28 April, 2020

Harbourside Shopping Centre Redevelopment SSD-7874

- EXISTING SHADOWS (INCLUDING EXISTING HARBOURSIDE RETAIL)
- PROPOSED ENVELOPE SHADOWS
- INDICATIVE CONCEPT SCHEME SHADOWS
- OVERLAPPING SHADOWS FROM BOTH THE PROPOSED ENVELOPE AND THE INDICATIVE CONCEPT SCHEME

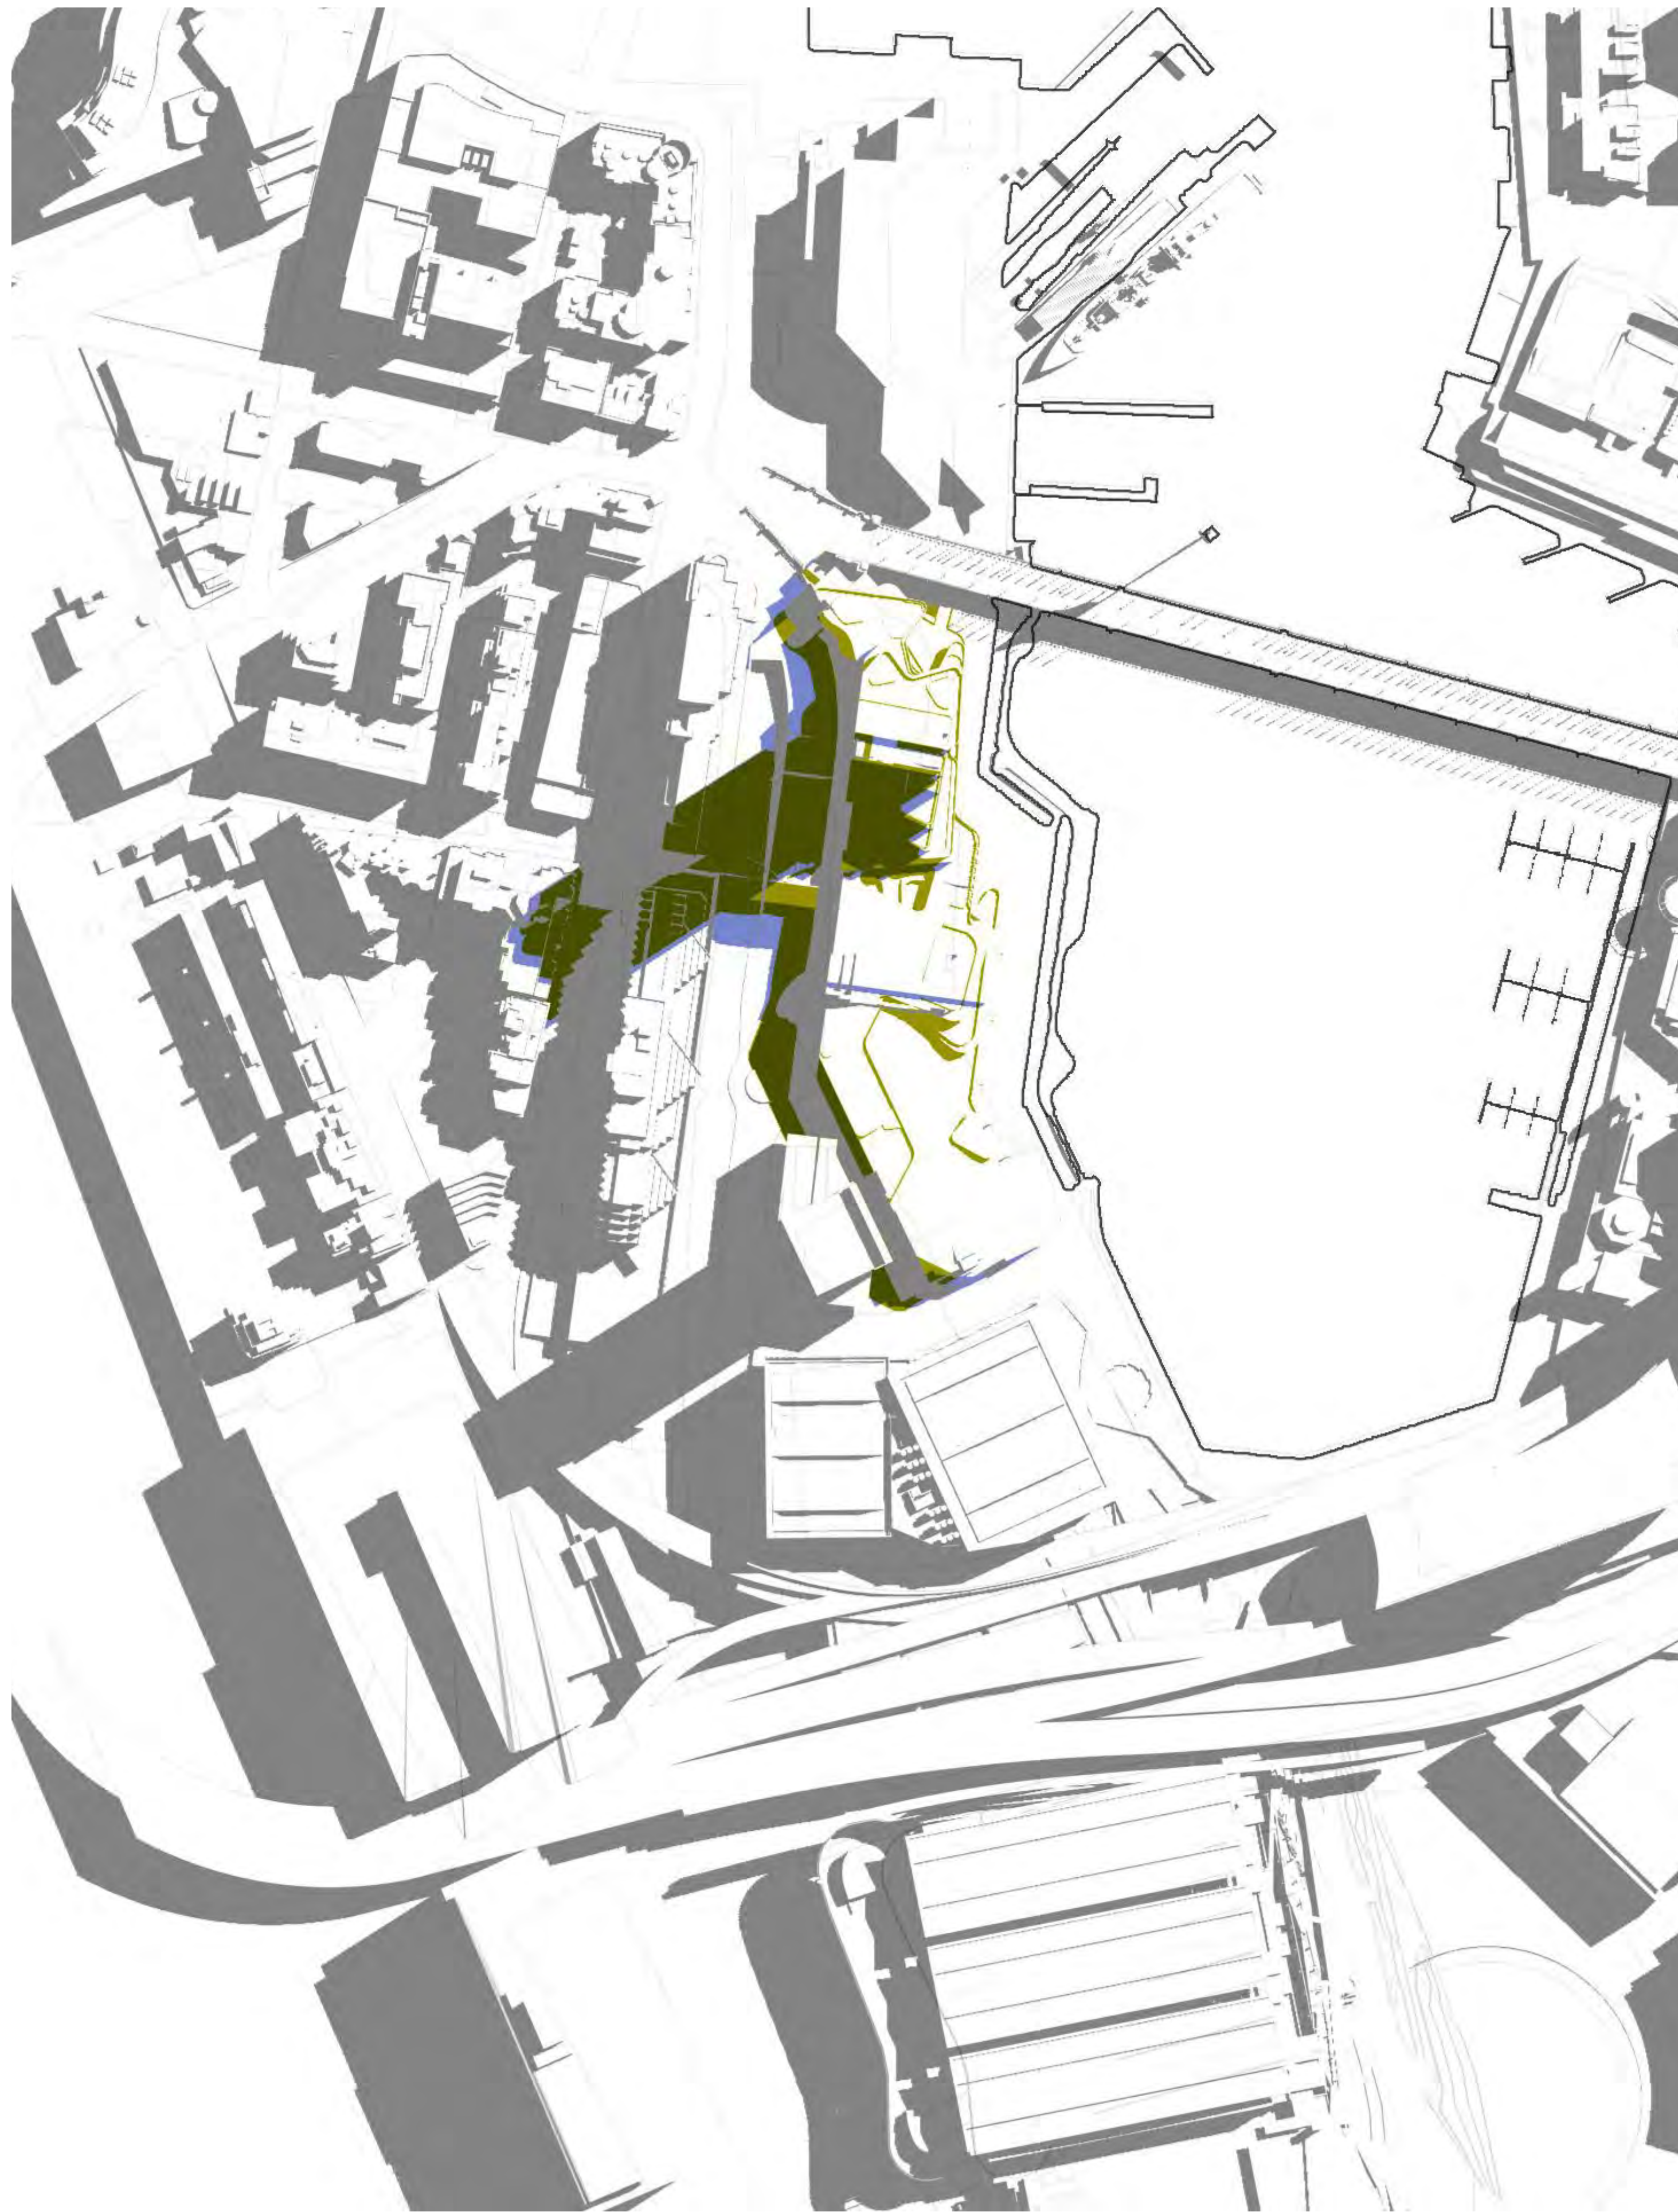
The proposed new podium appears to reduce the width of the existing promenade and increase overshadowing, compounding the impacts of the overshadowing from the new tower proposal particularly in the colder months of the year.
